# KITTITAS COUNTY DEPARTMENT OF PUBLIC WORKS

## MEMORANDUM

TO: Community Development Services  
FROM: Christina Wollman, Planner II *aw*  
DATE: April 24, 2009  
SUBJECT: No 6 Road Short Plat SP-09-00003

NO. 6 ROAD SHORT PLAT
PART OF SECTIONS 29 & 30, T. 17 N., R. 19 E., W.M.
KITTITAS COUNTY, WASHINGTON

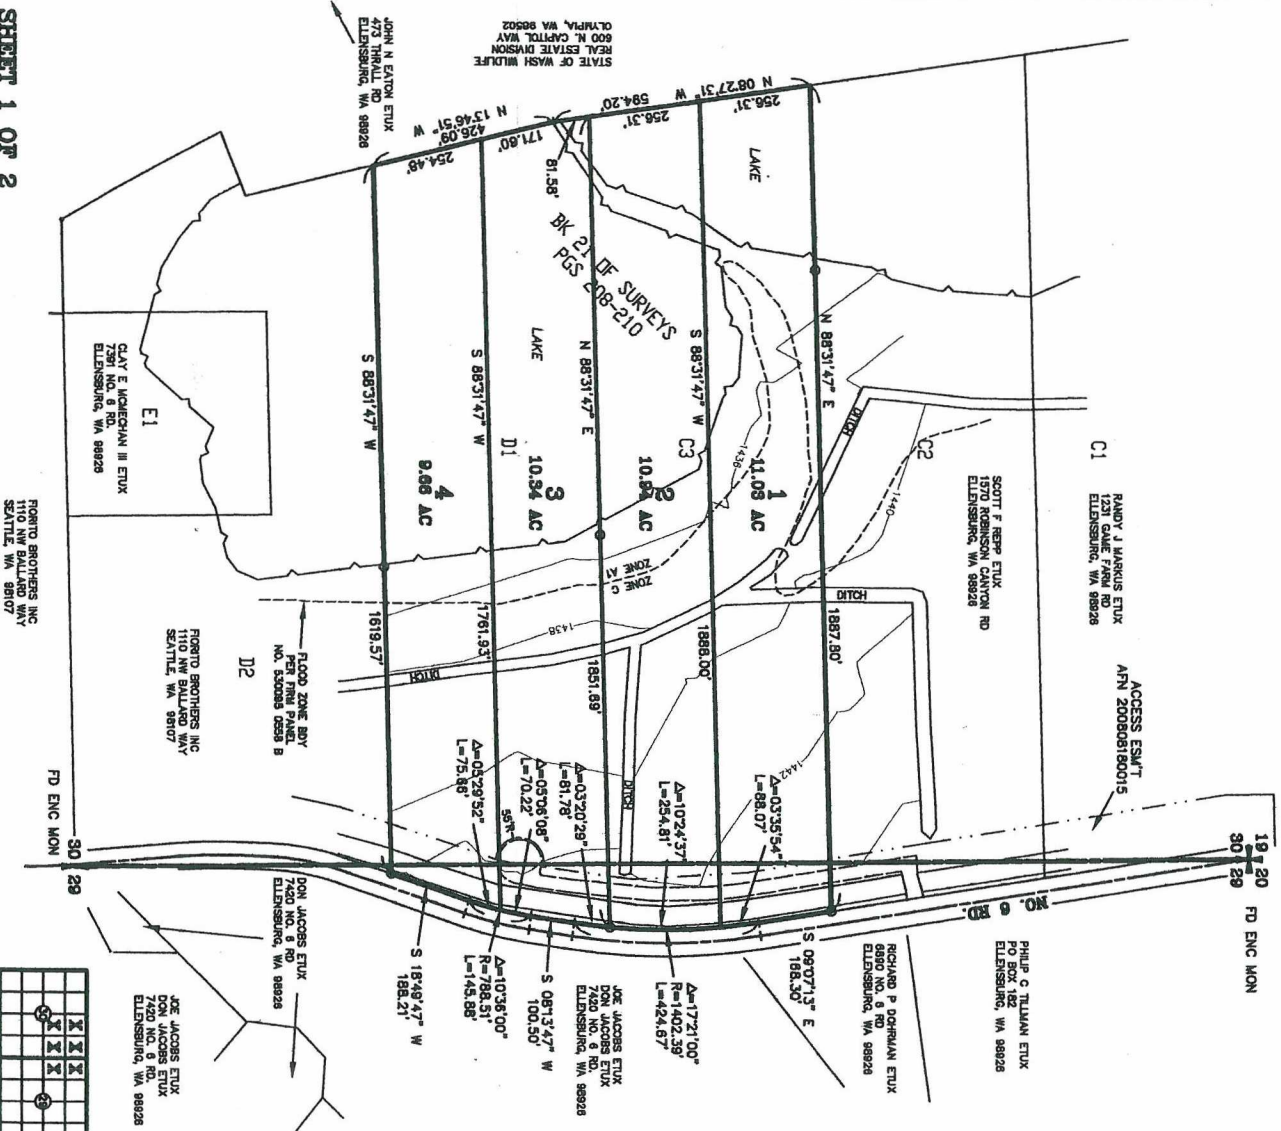
3. Access: The access onto the County road shall be shown clearly on the face of the plat.
4. Private Road Improvements: Access from No. 6 Road to the cul-de-sac shall be constructed to meet or exceed the requirements of a Low-Density Private Road. See Kittitas County Road Standards, 9/6/05 edition.
